ASSESSMENT REPORT

Printing Warehouse and Distribution Facility Erskine Park Penrith MP 08_0016 MOD 2

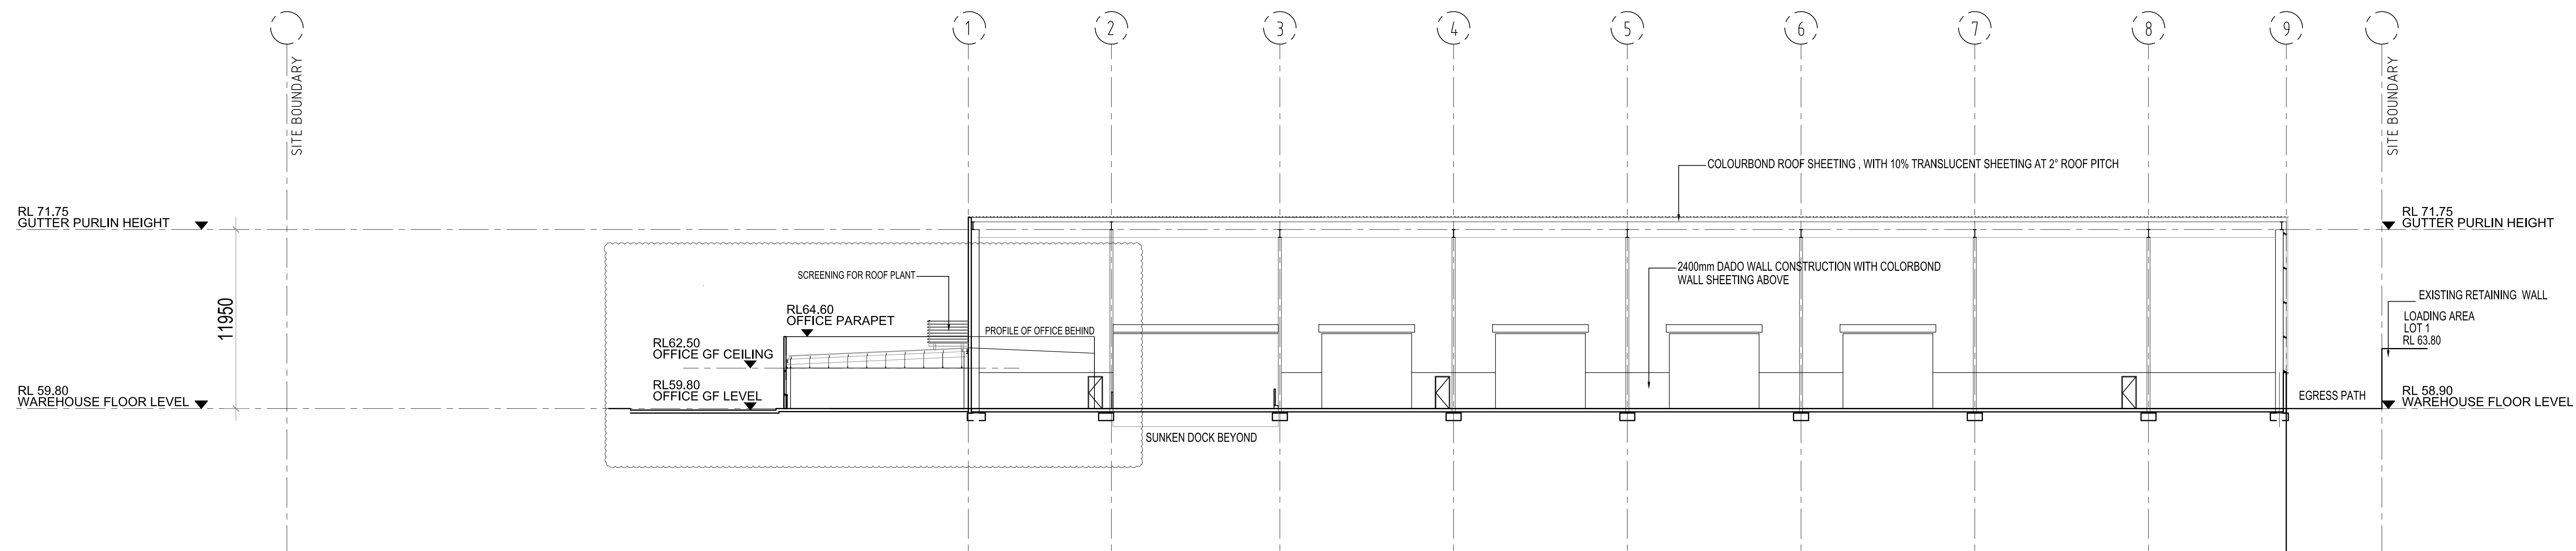
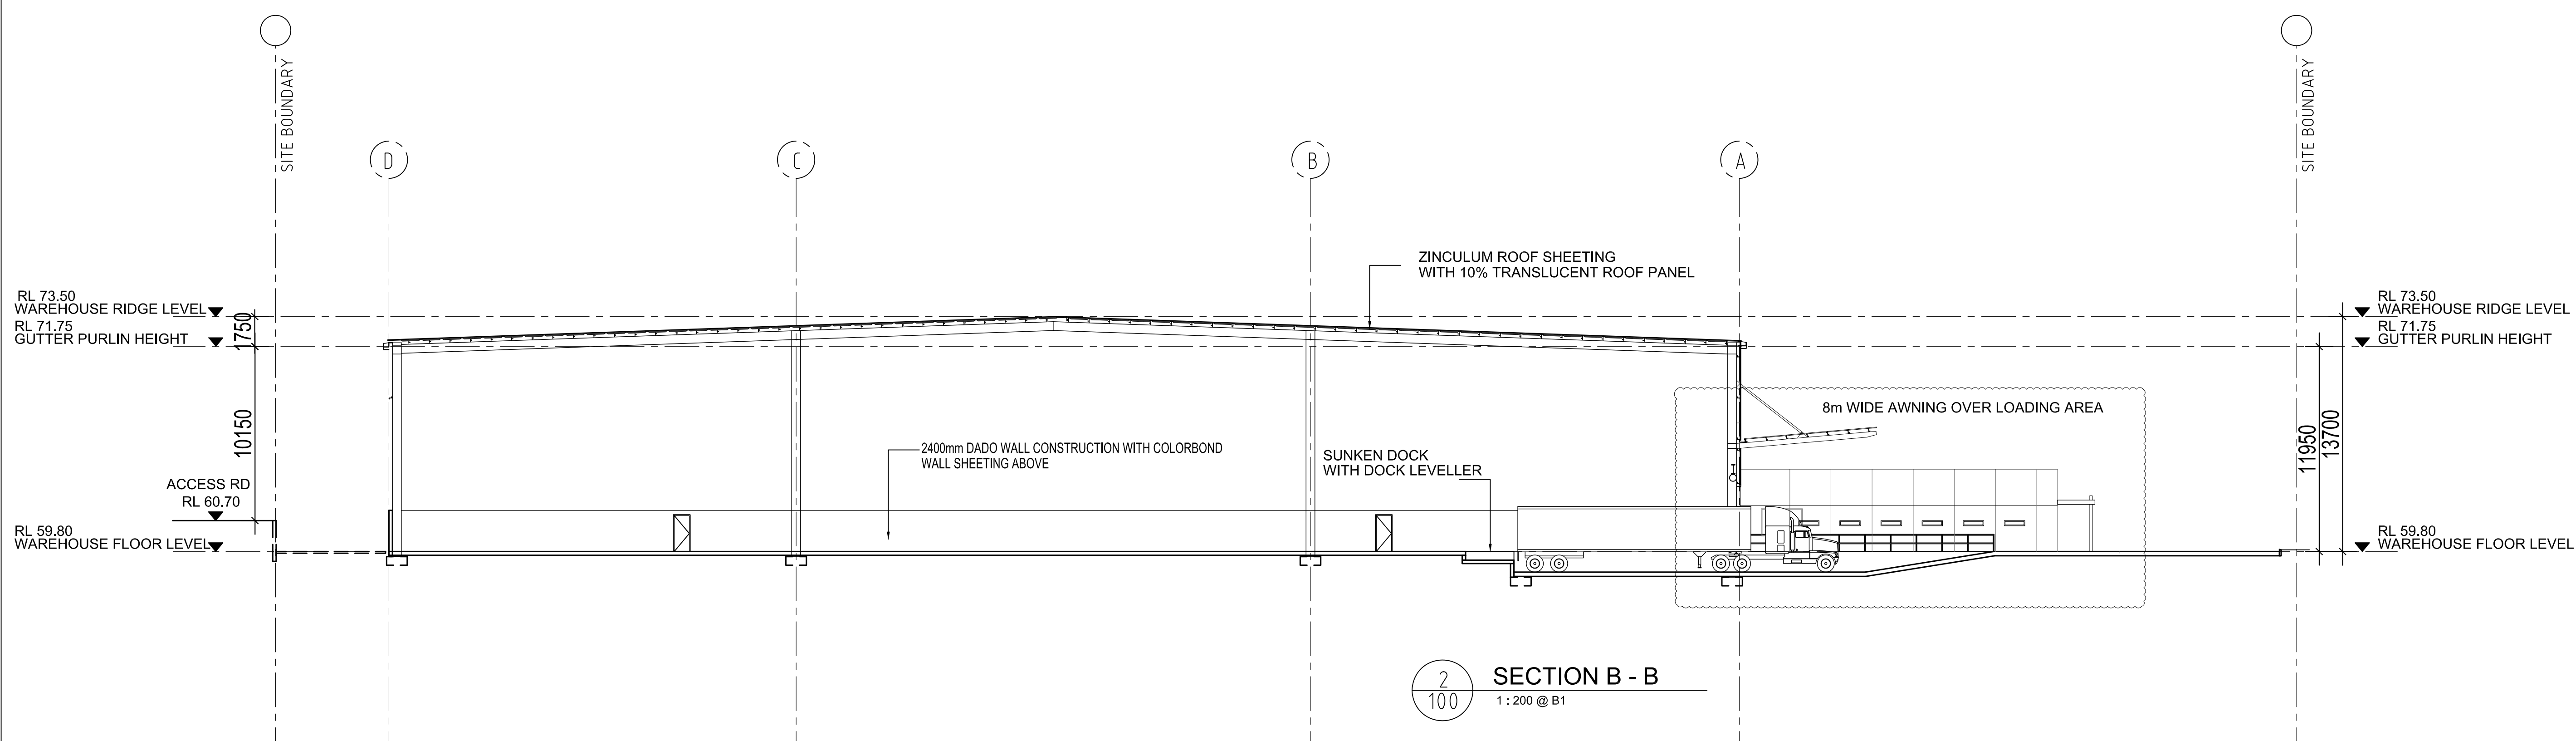
Issue	Consideration	Recommendation
<i>Building Height</i>	- The proposal seeks to increase the height of Warehouse 1 by 1.64m from 12.06m to 13.7m. - The proposed building height would exceed the Penrith City Council's DCP Height control of 12 metres, by 1.7 metres. - The Department notes the proposed height would be similar to the approved height of Warehouse 2 (13.73m), which was previously assessed as acceptable as it would not result in any adverse impacts on surrounding properties or the character of the area. - Although similar in height, Warehouse 1 (RL 73.50m) is situated on lower lying land and would sit 3.83m below Warehouse 2 (RL 77.33m). - The Department is therefore satisfied the proposed height increase to Warehouse 1 would be minor and in keeping with the height of other surrounding industrial properties. Further the Department is satisfied that the proposal would not result in any adverse visual or amenity impacts.	No additional conditions or amendments necessary.
